Application number: 2023/93076	
What is the application for?:	External alterations to former bank building to form restaurant and takeaway, in
Address of the site or building:	former Lloyds Bank, 22, Carr Lane, Slaithwaite, Huddersfield, HD7 5AN
Postcode:	HD7 5UT

Drawing Proposed Elevations	Scale @ A1 1:50
---------------------------------------	---------------------------

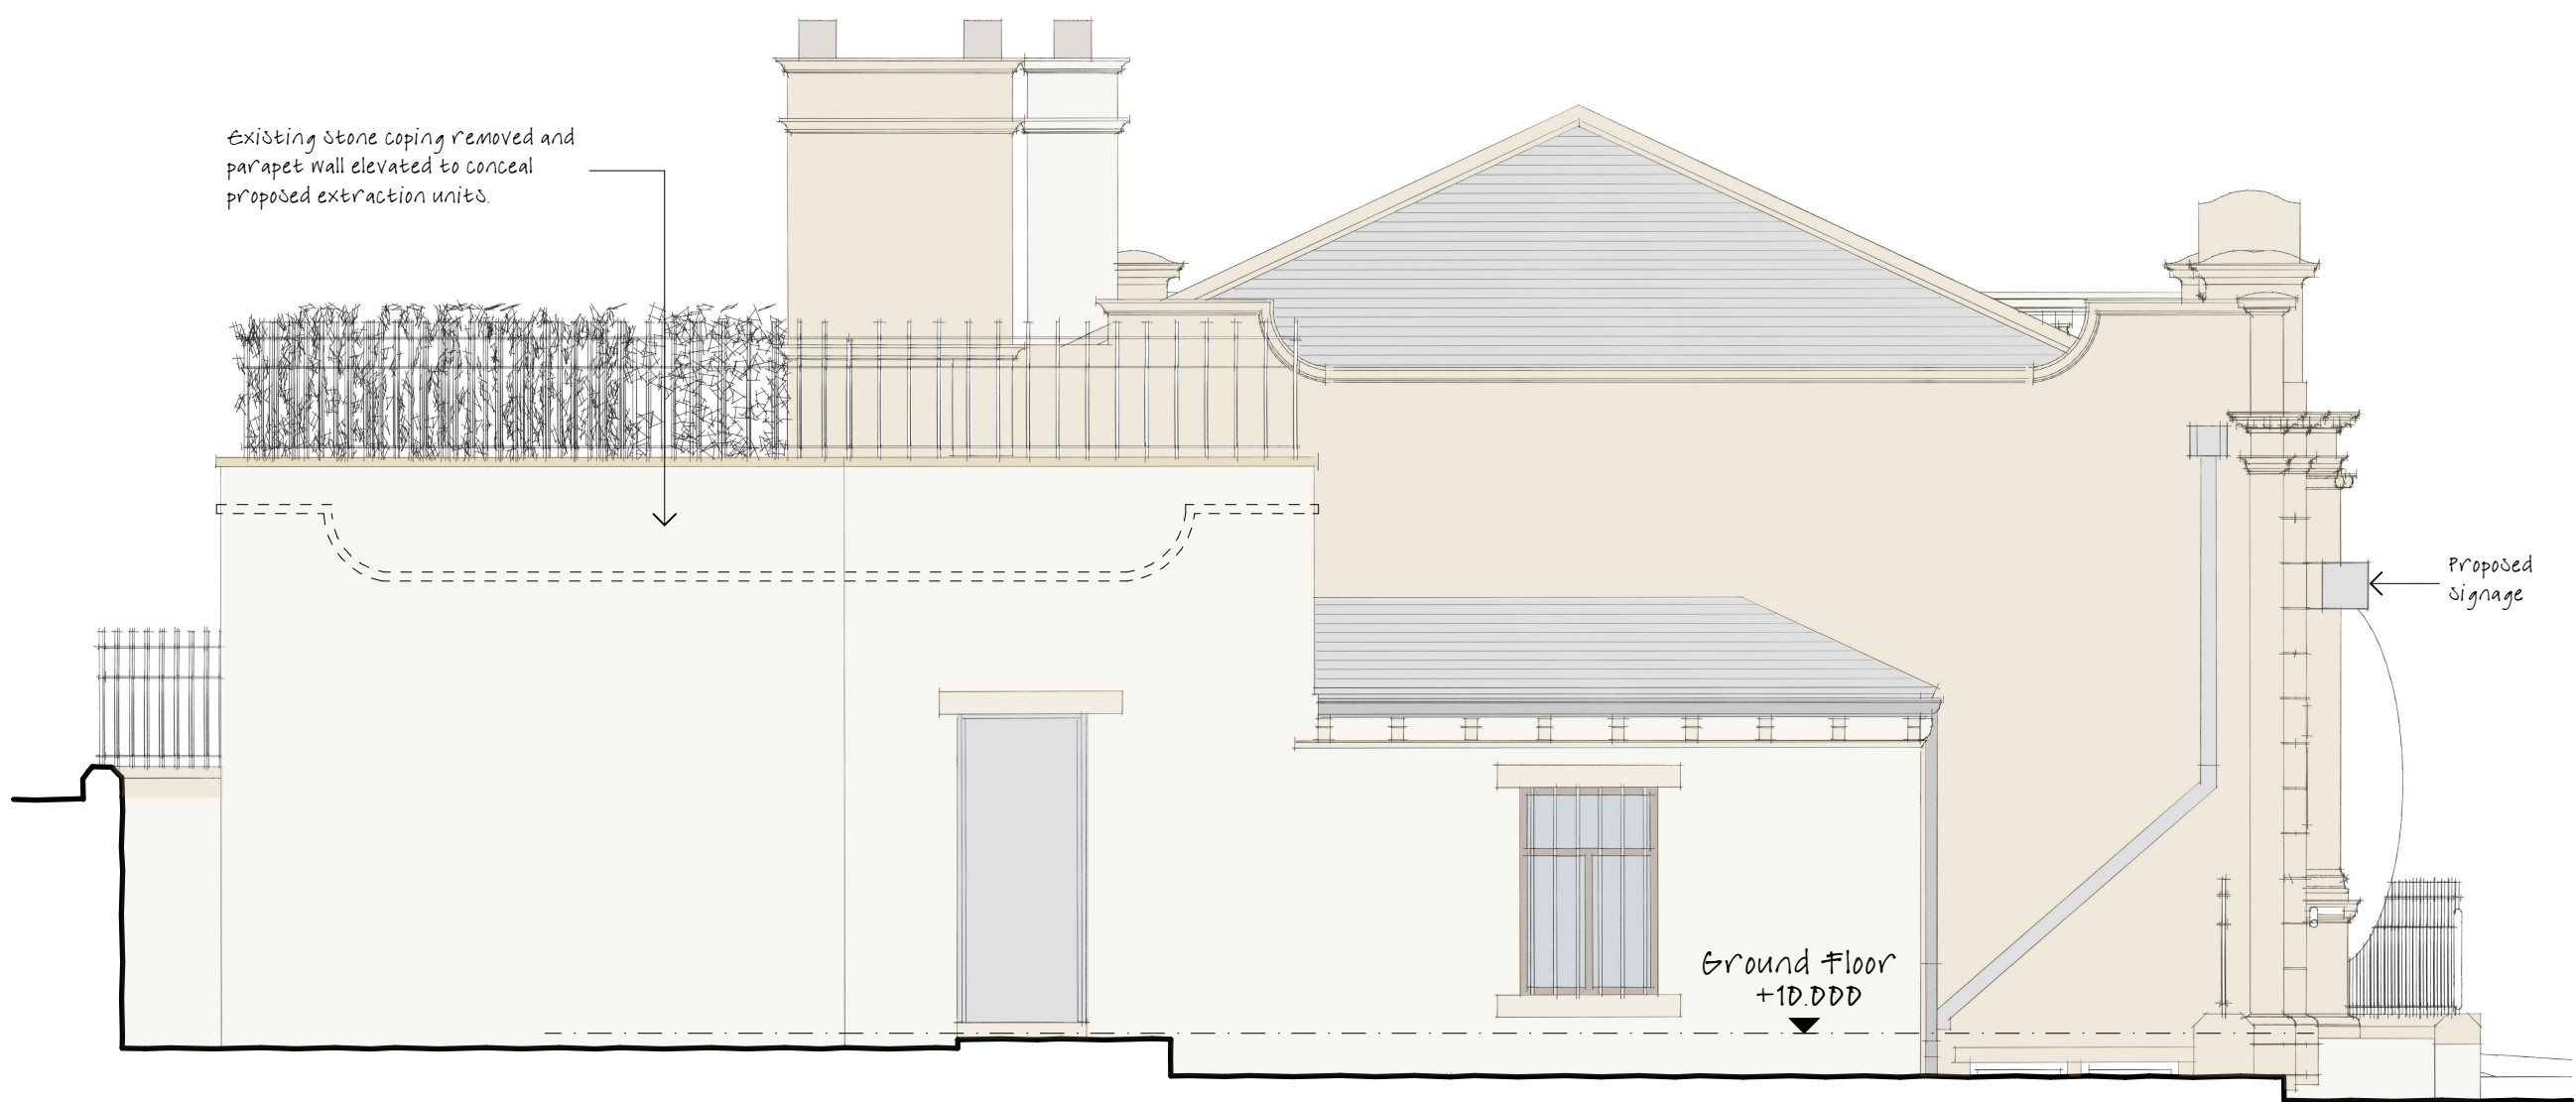
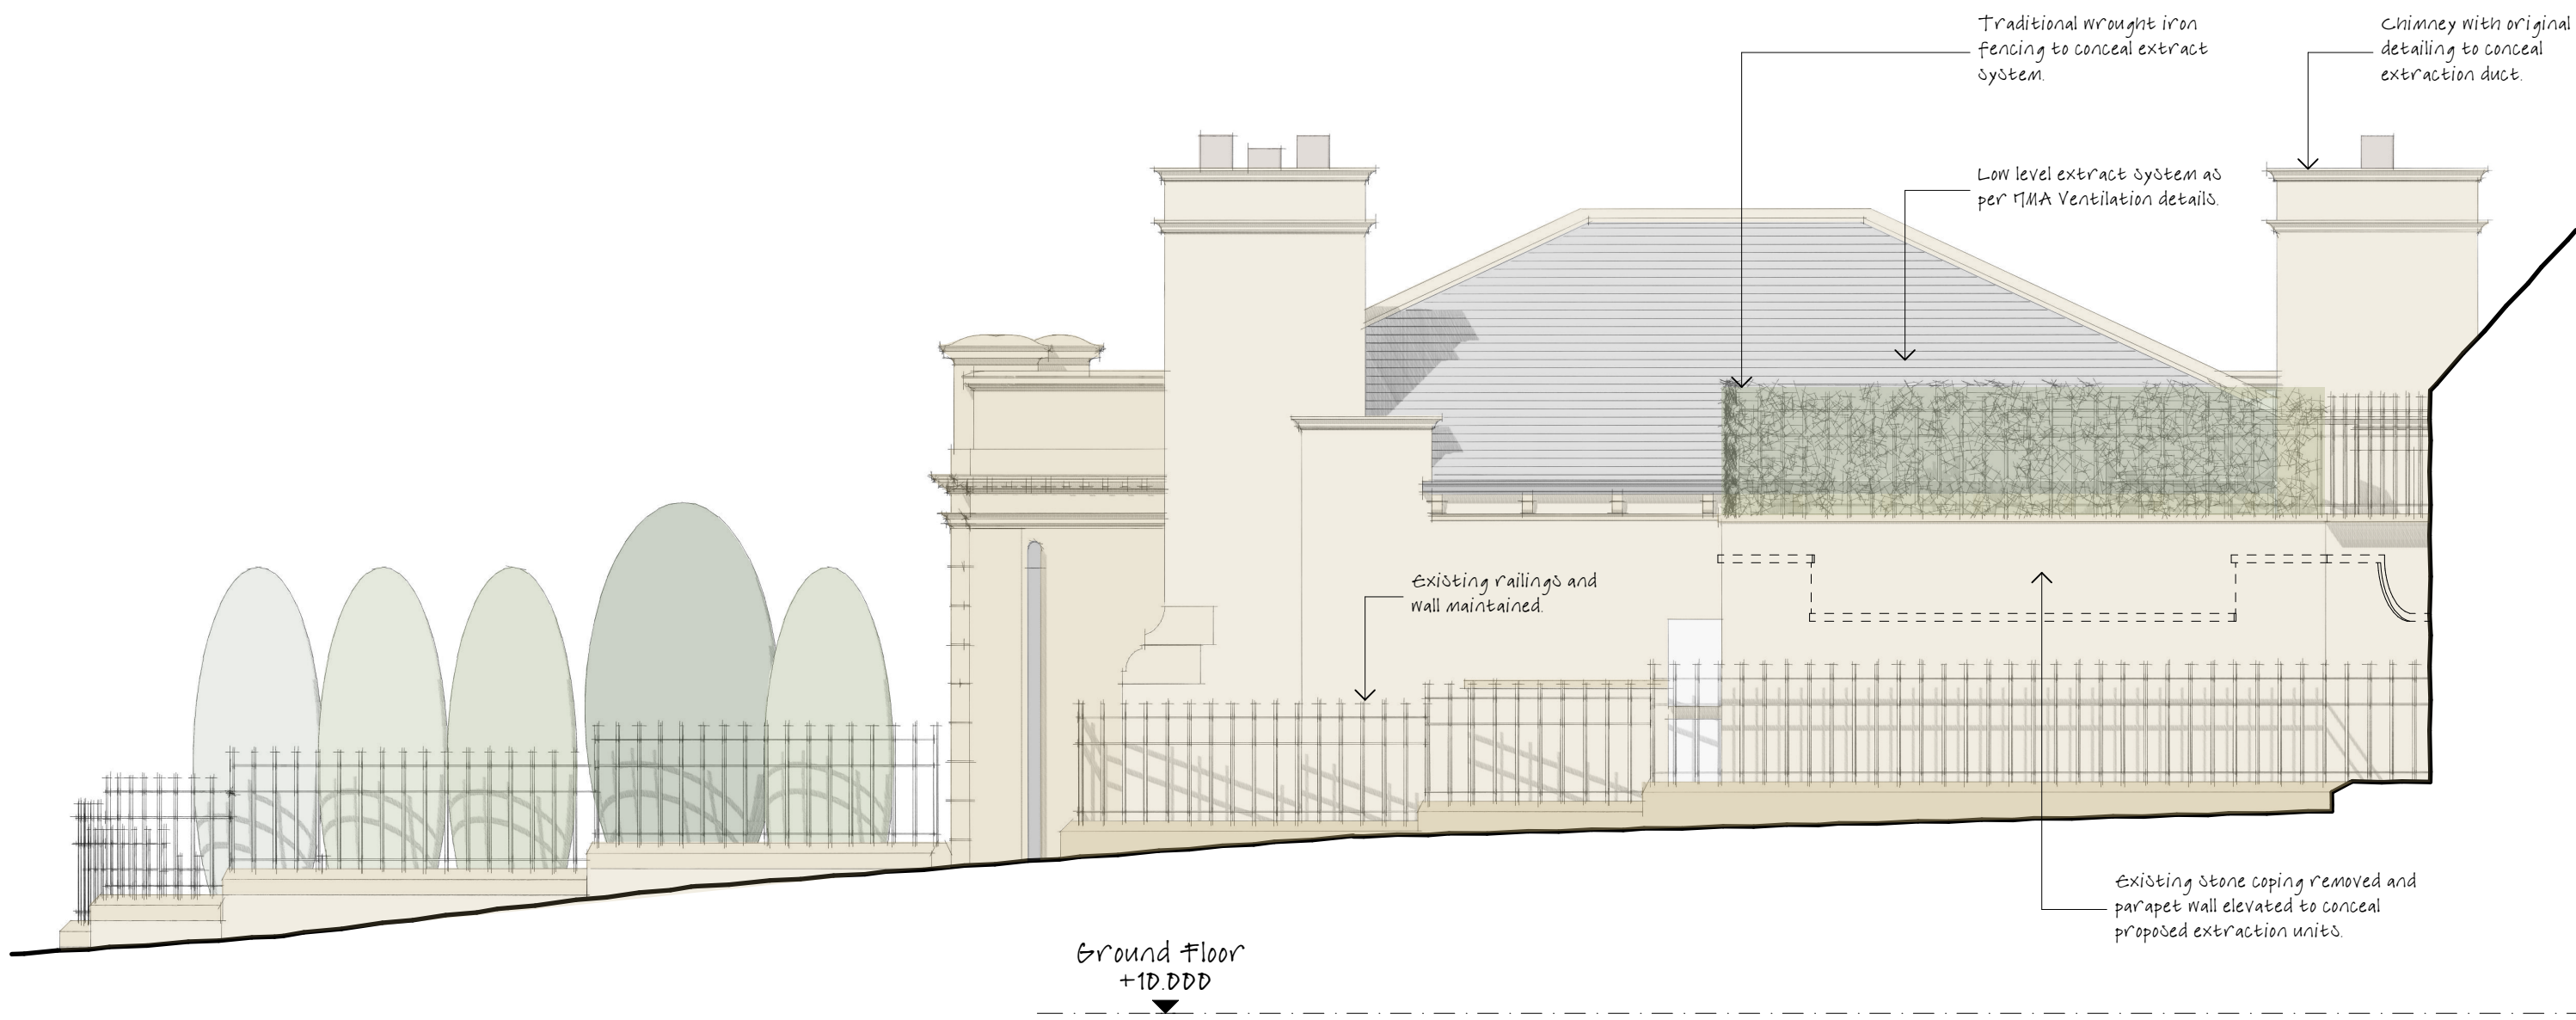
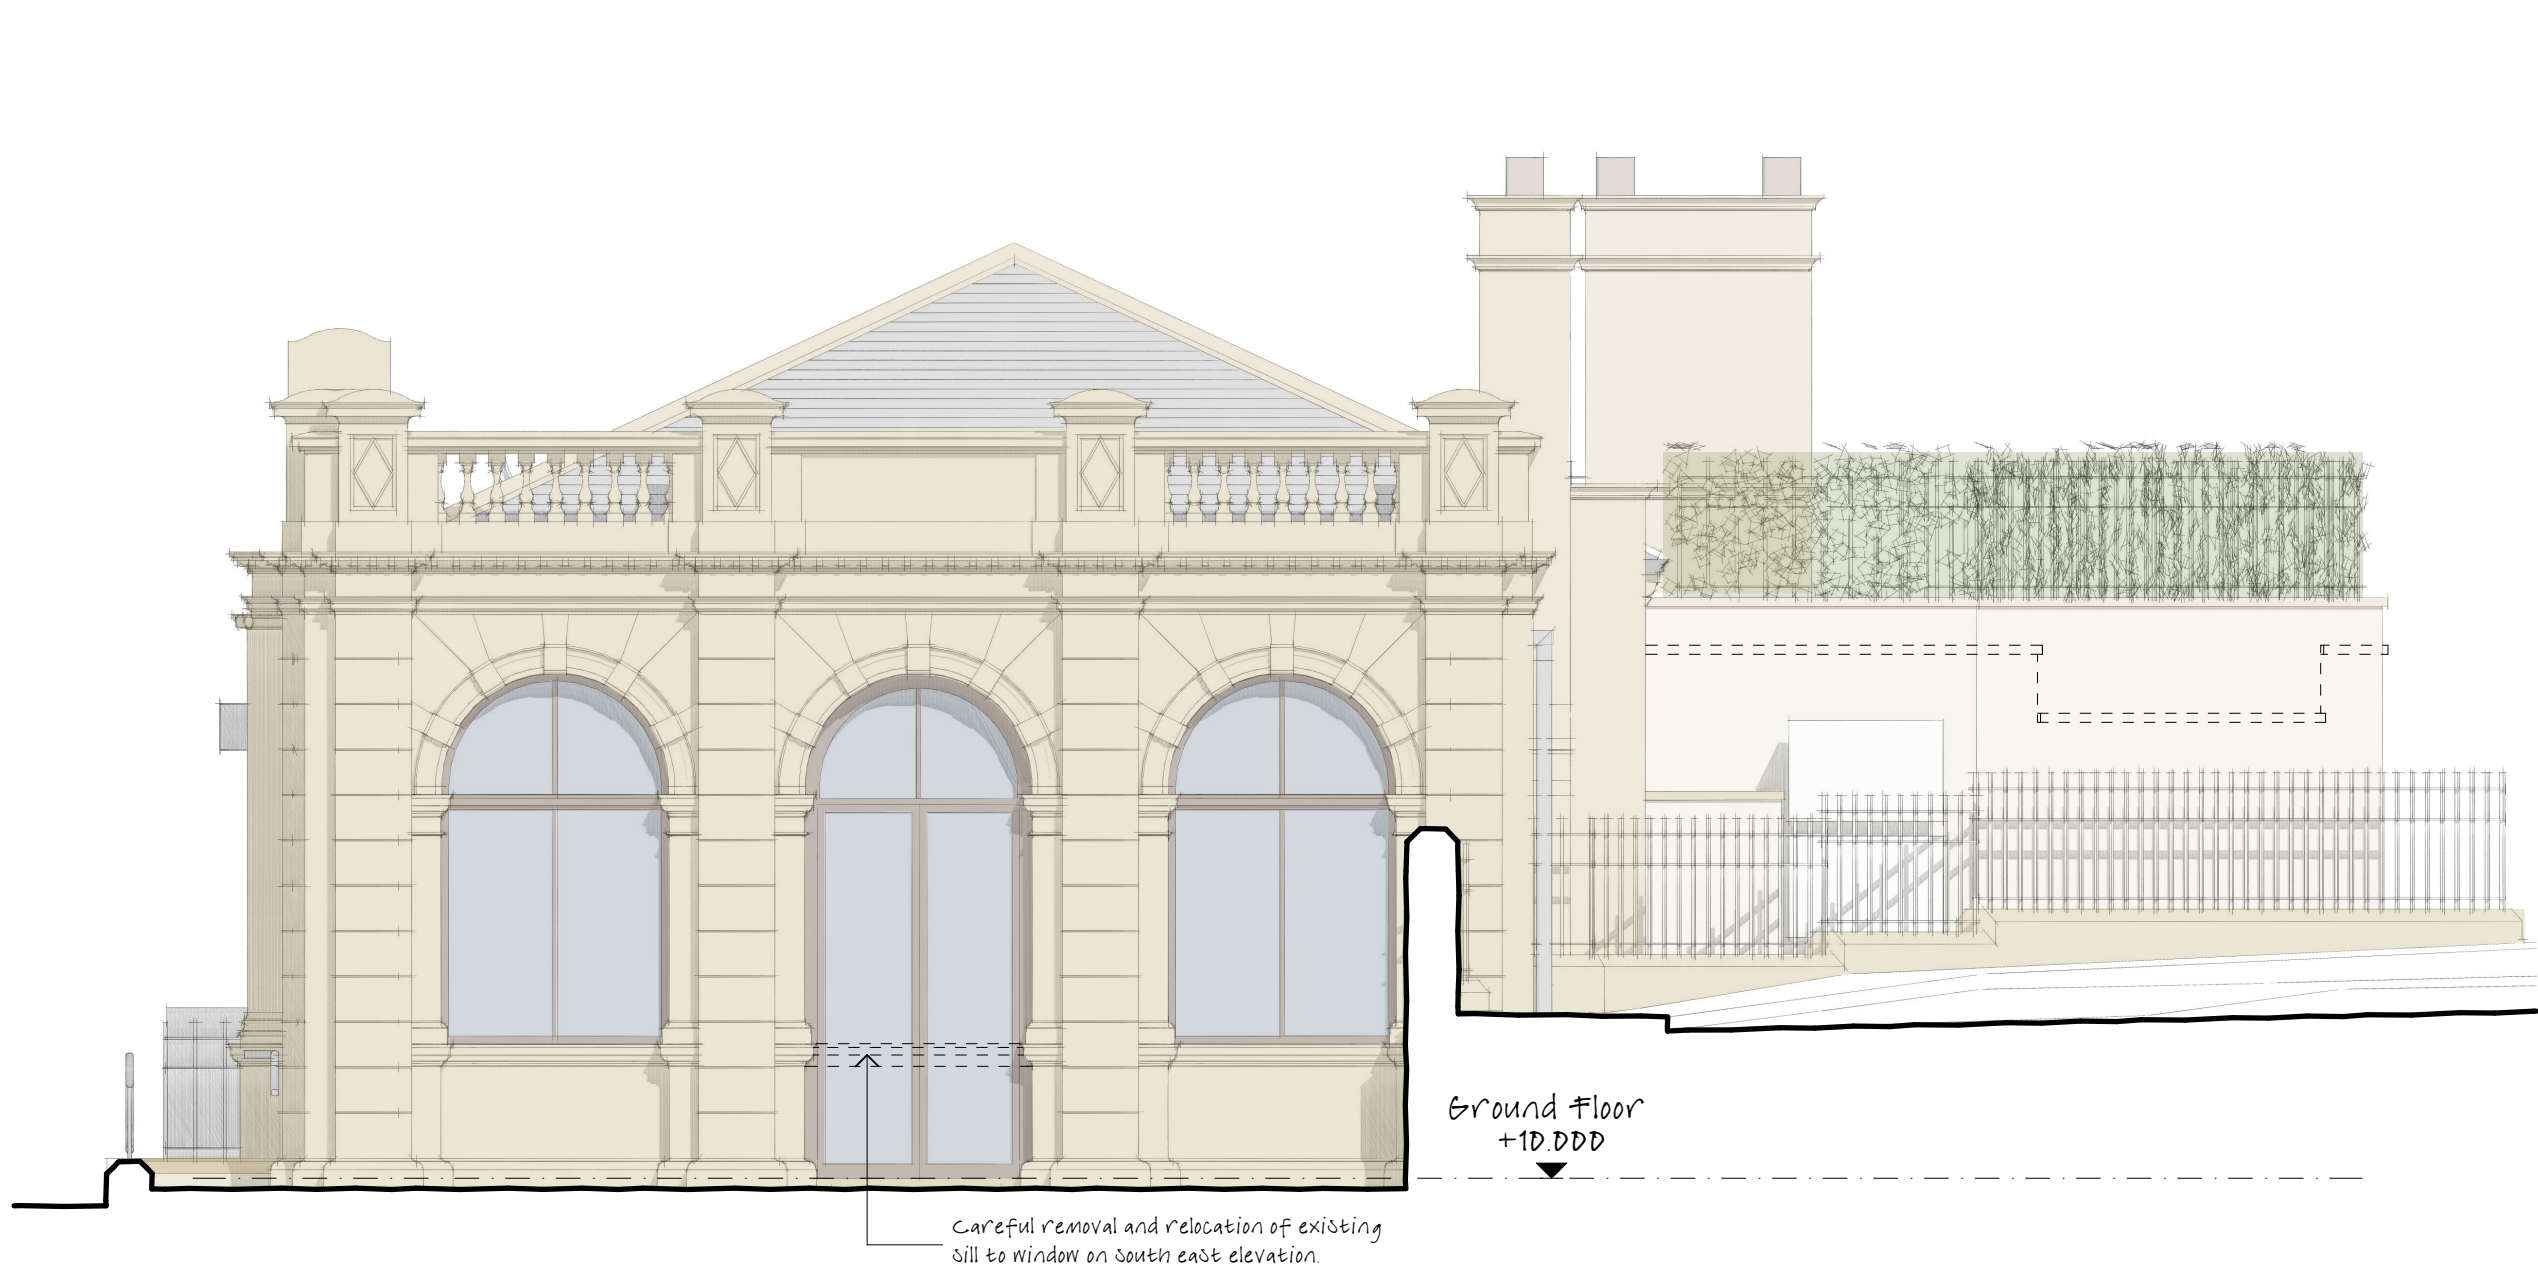
Type of comment: An objection	
Do you wish your comments to be published on the website anonymously?	Yes
Having looked at the revised plans for the development, all my previous objections remain the same. The addition of the chimney does not in any way address the odours that will emanate from the proposed business. The bin store as shown on the revised plans, is approximately half the size of the area the bins currently occupy at the existing business and there are also two drain pipes situated in this area (cast iron) that will prevent any bins fitting flush to the wall. None of these alterations have addressed any issues raised in the objections.
